08 February 2010

Joe Russell-Wells
Parks and Landscape
37914

Neil Crowther
Planning Services

ANGELS NURSERY SITE YAPTON ROAD BARNHAM – BN/27/09

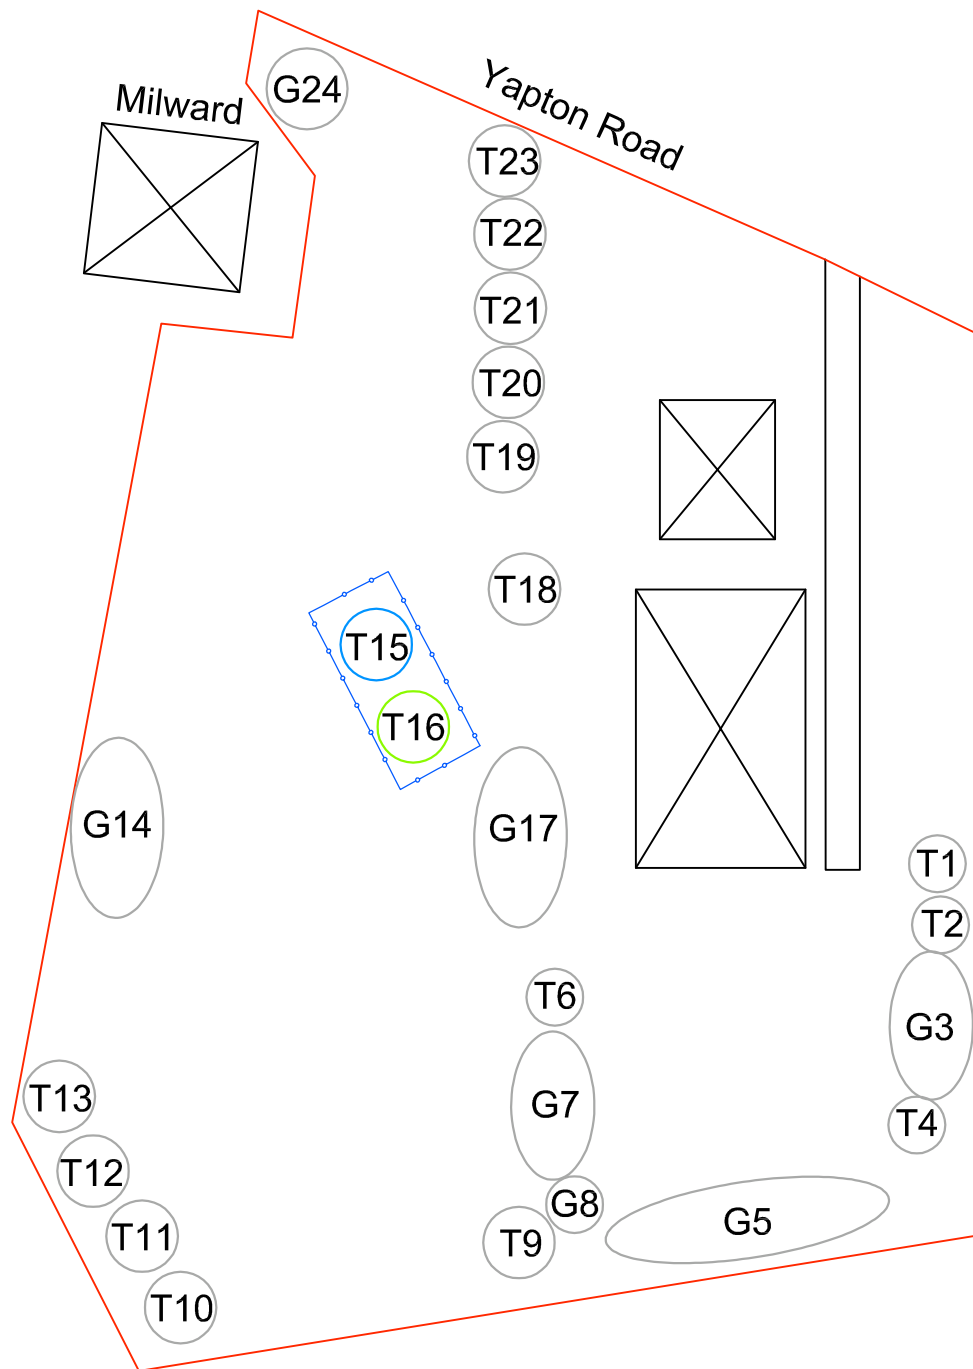
The section surveyed has failed to identify additional trees for example the Horse Chestnut near to T18 and young Oak trees growing between T15 and T18 on the Tree Constraints plan. They could be a material consideration as part of a proposed open space or considered for relocation appropriately in another part of the development site.

Some trees species have been incorrectly identified, for example T19 to T23 are a line of *Populus x euramericana* 'Hybrid Black and not White Poplar.

The Tree Constraints Plan has not been produced to scale. It cannot therefore be relied upon to provide the correct information with regard to tree location. It is imperative that this information is plotted onto a scale plan and submitted as part of the outline application.

The tree assessment is not conclusive. The retention of trees within the development only show two Oaks T15 and T16 on the plan. However other trees to be retained within the development site are shown on the Tree Constraints Plan but without protective fencing. Clarification of the trees to be retained within the the development including protective fencing must be made with the outline application in accordance with BS5837 (2005). Applying tree protection conditions on a reserve matters application will not protect the trees if they are already condemned by outline permission.

The report gives the measured tree diameter at breast height (dbh) and the root protection area calculated in Appendix 1 of the Tree Constraints Plan. Showing a protective fence on an un-scaled plan cannot be relied upon and is inadequate to protect the trees from harmful development activities. There is an inaccuracy

with some of the dbh measurements which need to be checked so that correct RPA distance can be plotted and the arboriculture constraints shown accurately.

- The survey must be complete and accurate (with particular reference to the inclusion of all trees, correct species and dbh)
- This must be reflected in the Tree Constraints Plan provided to scale
- The Tree Constraints Plan must reflect accurately the trees to be retained as part of the development, clearly identifying the location of protective fencing.
